**Our ref:** HA/2025/127004/01-L01  
**Your ref:** LU/141/25/PL  
**Date:** 05 September 2025

**PARTIAL DEMOLITION OF NUMBER 57 RIVER ROAD, CHANGE OF USE & RE-DEVELOPMENT TO PROVIDE A FLATTED DEVELOPMENT COMPRISING 9 NO APARTMENTS WITH PRIVATE AMENITY SPACE, PARKING & CYCLE STORAGE, INCLUDING THE PARTIAL DEMOLITION OF THE ADJACENT BOUNDARY WALL TO PROVIDE A NEW PEDESTRIAN ACCESS & THE CREATION OF A FLOATING PONTOON WITH RESIDENT MORNING SPACES (RESUBMISSION FOLLOWING LU/251/21/PL). THIS APPLICATION AFFECTS THE CHARACTER & APPEARANCE OF THE LITTLEHAMPTON RIVER ROAD CONSERVATION AREA & IS IN CIL ZONE 4 (ZERO RATED) AS FLATS.**

**57 RIVER ROAD, LITTLEHAMPTON, BN17 5DD.**

**Environment Agency position**

The proposed ground, first, second and third floor layouts are shown in Figures 3.1 to 3.4 below for reference.

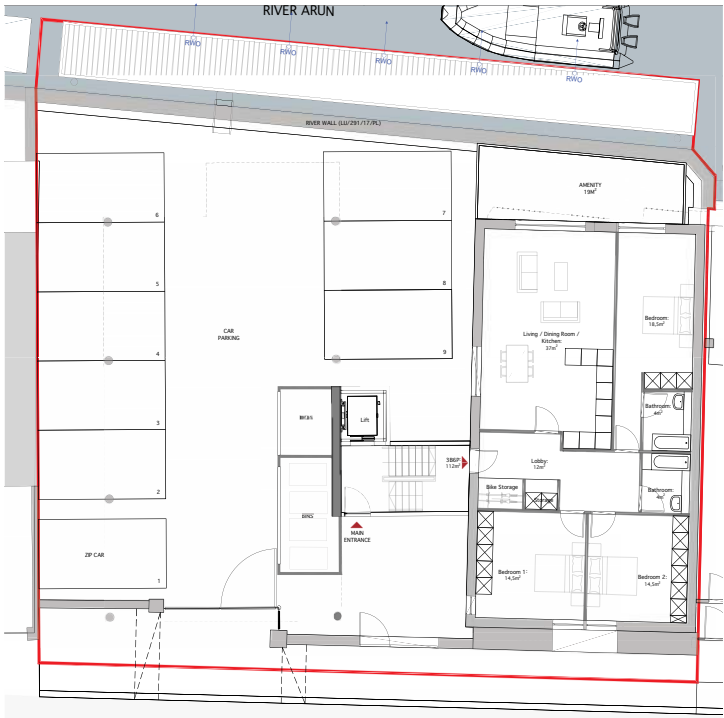
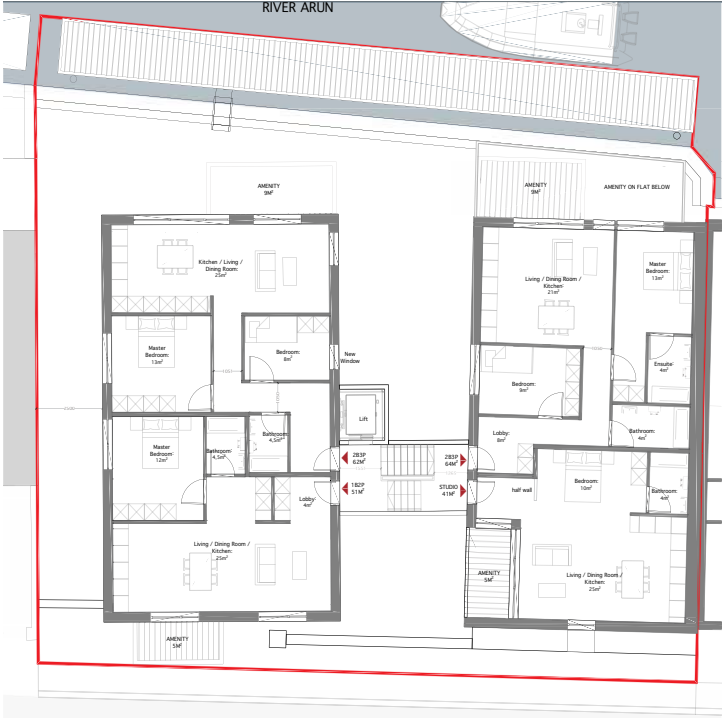
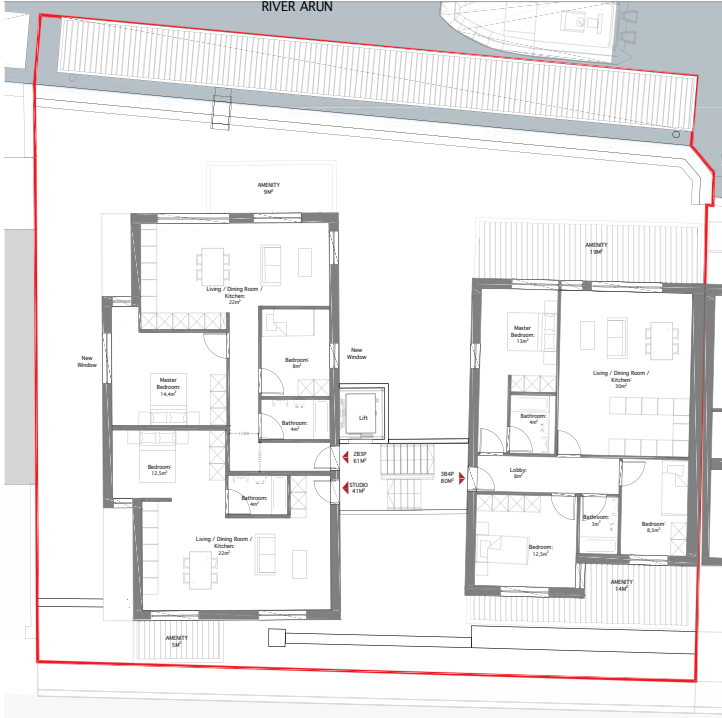
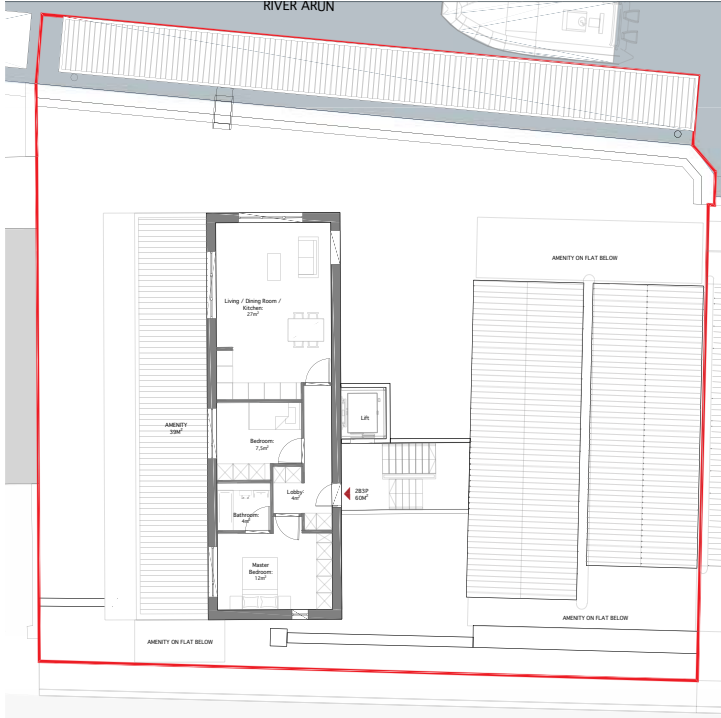
· Flood risk mitigation measures to address flood risk for the lifetime of the development included in the design are inadequate because they will not make the development resilient to the flood levels for the 0.5% AEP CC, with 600mm freeboard as recommended in government guidance. Consequently, the development proposes inadequate raised finished floor levels

Since this time, government guidance has been extensively updated and now recommends that finished floor levels should be a minimum of 600mm above the estimated river or sea flood level. The FRA for this application proposes the same floor levels as in the 2021 application but does not adequately justify why these are acceptable. It only states that the chosen floor level is suitable for a 1 in 300 event, with no evidence of how this was deduced or relates to the design flood level, or any consideration of whether this includes allowances for climate change.

To overcome our objection, the applicant should submit a revised FRA which addresses the points highlighted above.
